Proposed Housing at Lingards Road for SB Homes Ltd Planning Application 2020/62/93954/W

Comments from Lingards Residents in response to revised application drawings issued September 2022

Comments by applicant and design team in response 18/11/22 Additional Comments 23/11/22

Project HOUSING AT LINGARDS RD SLAITWAITE
 Client SB HOMES LTD
 Drawing SITE SECTIONS ACROSS LINGARDS RD
 Scale 1:200
 Dwg No 2019 572 61

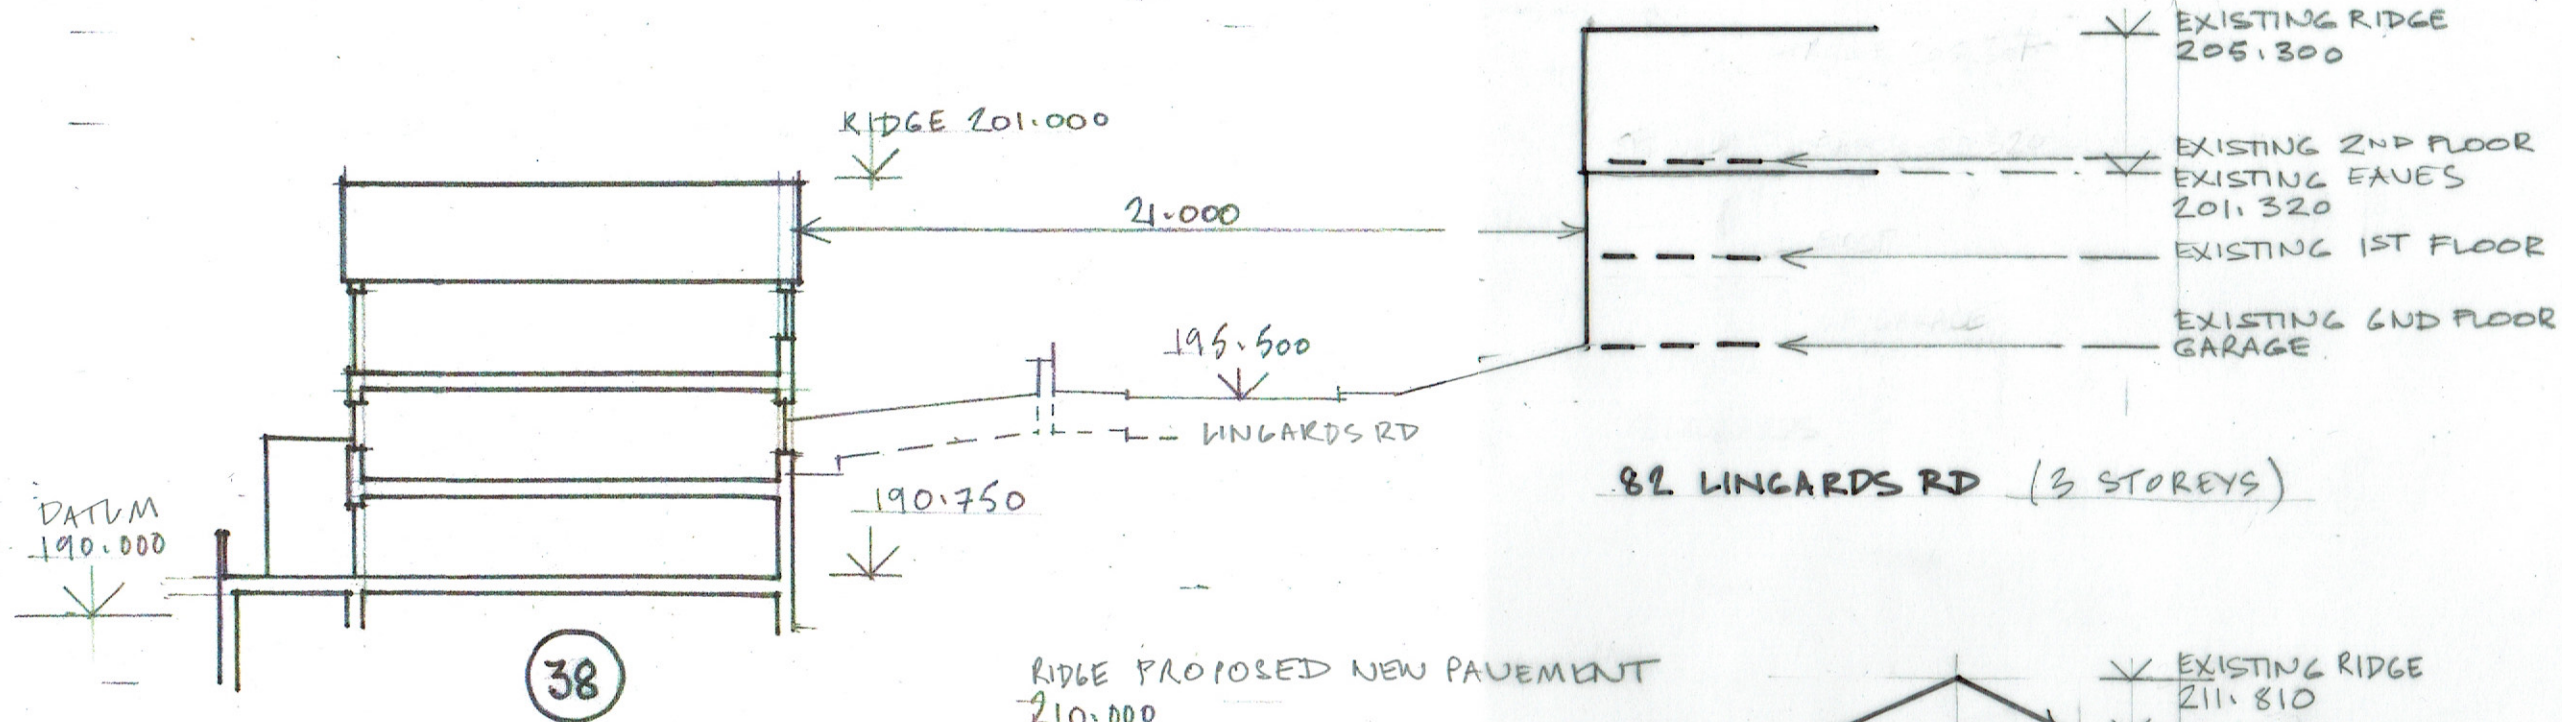
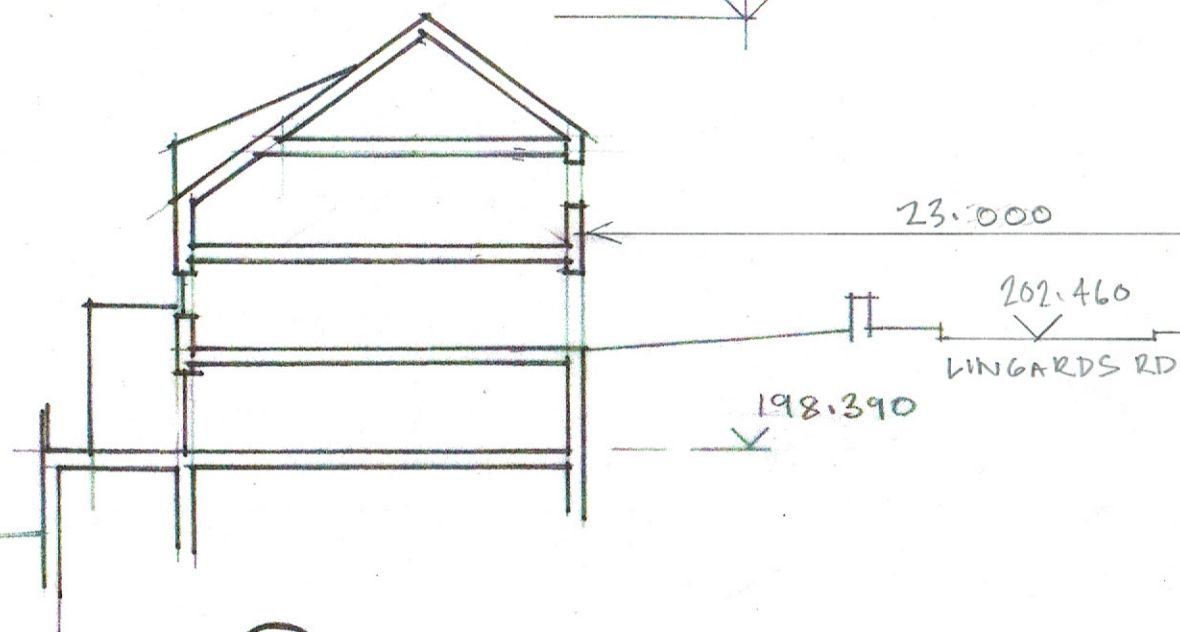
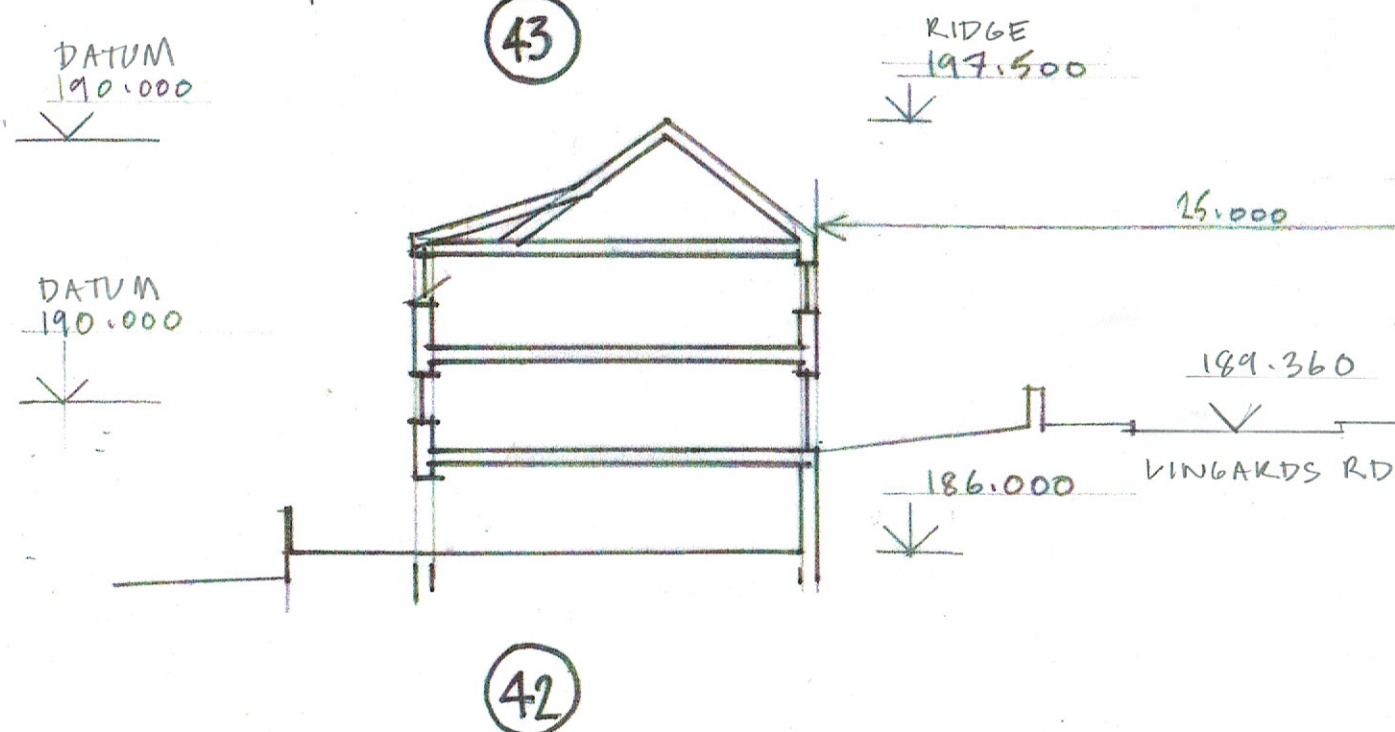
2 Urban Design and 3 Storey Houses not acceptable

3 storey houses are proposed built into the hillside presenting 2 storey facades towards Lingards Road which, despite the claims to the contrary by the residents, include 5 No existing 3 storey houses with lower ground garage floor, ground floor and first floor roof storey. The resultant section of the proposed dwellings reflect that of the existing with 3 storey houses built into the slope and should note ridge heights are either roughly equivalent or lower than the existing as shown on drawing 2019 572 61A. It should also be noted that some of numbers 37 to 45 Lingards Road present 3 storey rear elevations onto the application site where they contain

basement storeys. To say that 3 storey houses are out of character with the area is therefore incorrect and would suggest that the appearance of single storey facades (to 2 storey houses) facing into the hillside would be totally out of character and would appear as a row of bungalows.

Refer to Section Drawing 2019 572 61 A which shows the relationship between the houses along Lingards Road with the development site and Section Drawing 2019 572 53 B which shows the relationship between houses along Manchester Road and the proposed dwellings.

No habitable rooms within the development overlook existing and new by less than 21.0metres and the distances between the existing dwellings on Lingards Road and the proposed houses range from 21 to 24metres. It should be noted that the distance from the proposed dwellings to the rear facades of the houses along Manchester Road is between 32 and 43metres well in excess of planning guidance.
